Planning Application Reference: 6/2020/0392/HOUSE

We write to you in connection with the above planning application submitted by 9, Gorse Way, Hatfield AL10 9GS. We have examined on line plans and related documents and wish to object/concern to the development and would like to discuss with you prior to give any approval for this application.

DRAWING NUMBER: GLA-05L

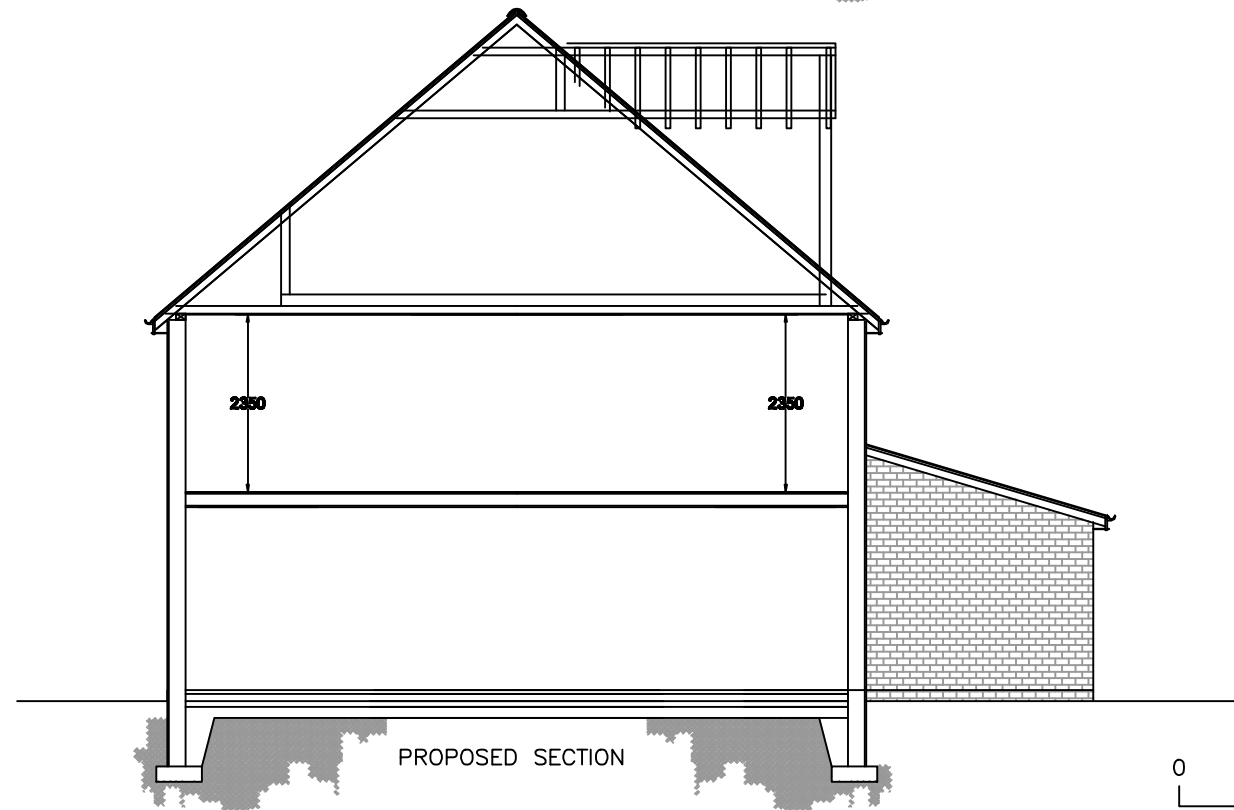
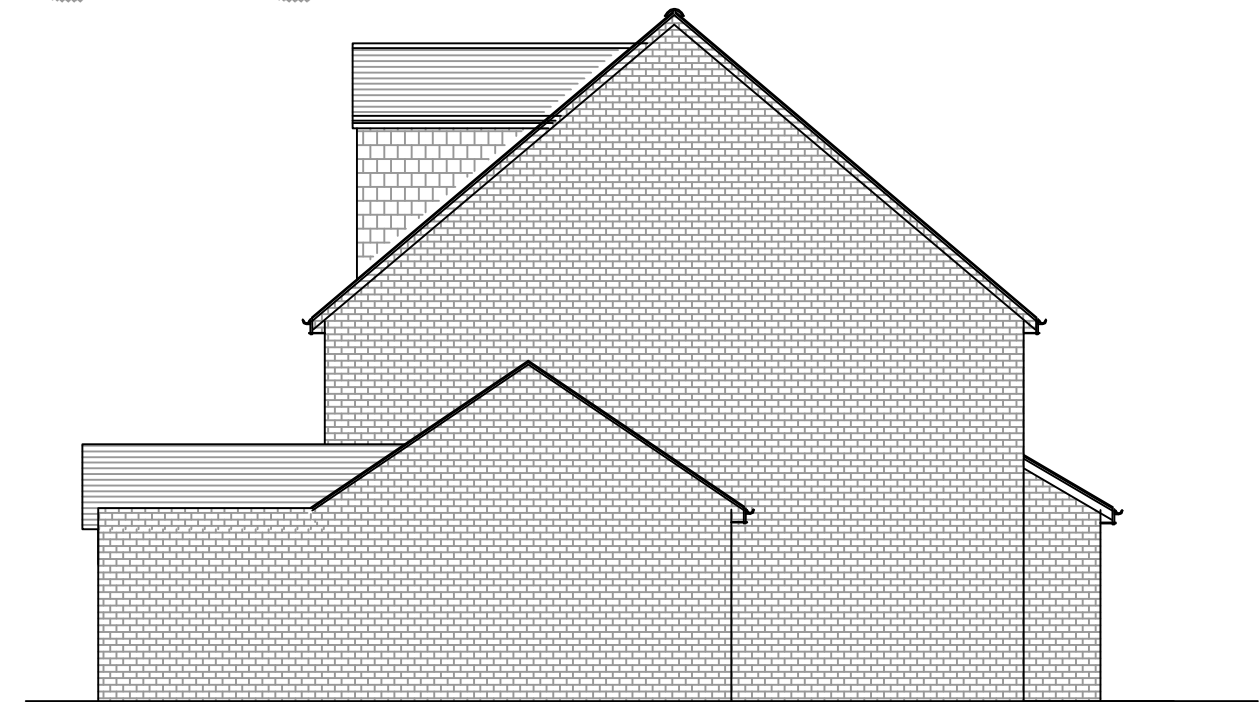
- B. Current plans/documents include Proposed Front and Rear Elevations do not have any dimensions mentioned for extension like height, width and distance from our property and seems wall is in our boundary.

- C. There are no details about foundation they will be digging within 3 metres of our property and what will be impact to our structure as we share party wall being a semi detach property.
- D. After Loft and Garage conversion at No. 9 Gorseway it will become a proper 4 + Bedroom property which means parking spaces must be considered to be available for more than 1 car.
- E. As we are legally entitled to appoint a surveyor and we would like to do either appoint a council surveyor or other available option to make sure a detailed survey to safeguard our rights and works are conducted lawfully and we do not suffer any unnecessary inconvenience by inconsiderate builders/workers and survey charges must be bear by the owner/s of No. 9 Gorseway, Hatfield AL10 9GS
